M25 junction 28 improvement scheme

TR010029

9.115 Applicant's comments on the Garden of Peace's Deadline 7 submission

June 2021

Drawing file: published-documents / TR010029-001054-PLAN 1 - PREM518-GEN-0000-0017 Rev H-Sht 2.PDF

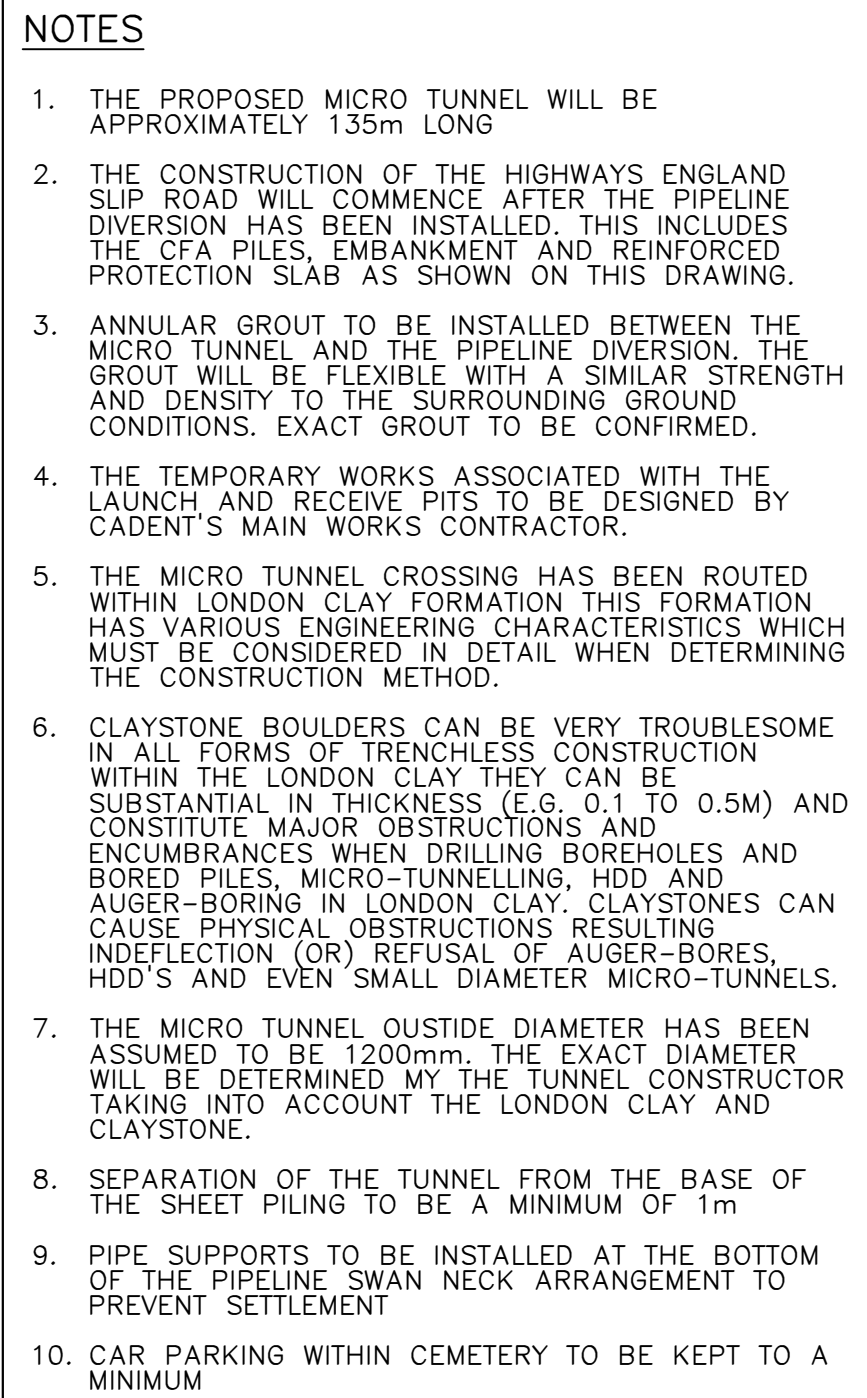
REP7-038-07	<p>Soil Storage</p> <p>REP5-066-09: <i>This has been discussed with all parties and a revised plan is being prepared to show concrete barriers around the storage area</i></p>	<p>This element has been agreed between all parties and shown on the drawing enclosed with the draft agreement.</p> <p>This has been discussed with all parties and a revised plan (as shown on Drawing Reference PREM518-GEN-0000-0017, Rev D) has been</p>

Response reference:	Question	Highways England Response
	<p><i>to prevent overspill from soil storage area onto adjacent storage areas.</i></p> <p>Gardens of Peace Comment: Gardens of Peace welcome the Applicant's confirmation that a plan identifying the concrete buffers around the soil storage area is being prepared. Accordingly, an obligation on Cadent Gas to install the concrete buffers around the soil storage area, to prevent overspill from soil storage area onto adjacent storage areas, has been included within the draft Tri-party Agreement.</p>	<p>shared which shows concrete barriers around the storage area to prevent overspill from soil storage area onto adjacent storage areas.</p> <p>The revised wording with regard to the soil storage is being considered by Highways England.</p>
REP7-038-08	<p>Plot 1/8 Fencing</p> <p>REP5-066-10: <i>Highways England has asked the solicitors representing the Trustees to provide comment on the draft agreement provided to them on 14 April 2021. The fencing and its design during construction will be confirmed in the next iteration of the draft agreement, following receipt of those comments.</i></p> <p>Gardens of Peace Comment: To re-iterate the concerns of Gardens of Peace, whilst the work plans prepared by Cadent Gas confirm that Plot 1/8 will be bounded by Heras fencing, the need for the Heras fencing to be cladded with</p>	<p>Highways England considers it inappropriate to directly refer to the brand 'Heras' in the agreement and has proposed removing the word 'Heras' from the clause and replacing it with a generic term. Suitable acoustic measures in respect of the boundary treatment as well as its visual appearance are under consideration.</p> <p>Fencing is shown along the boundary of Plot 1/8 during construction on Drawing Reference PREM518-GEN-0000-0017, Rev D which is included in the draft agreement.</p>
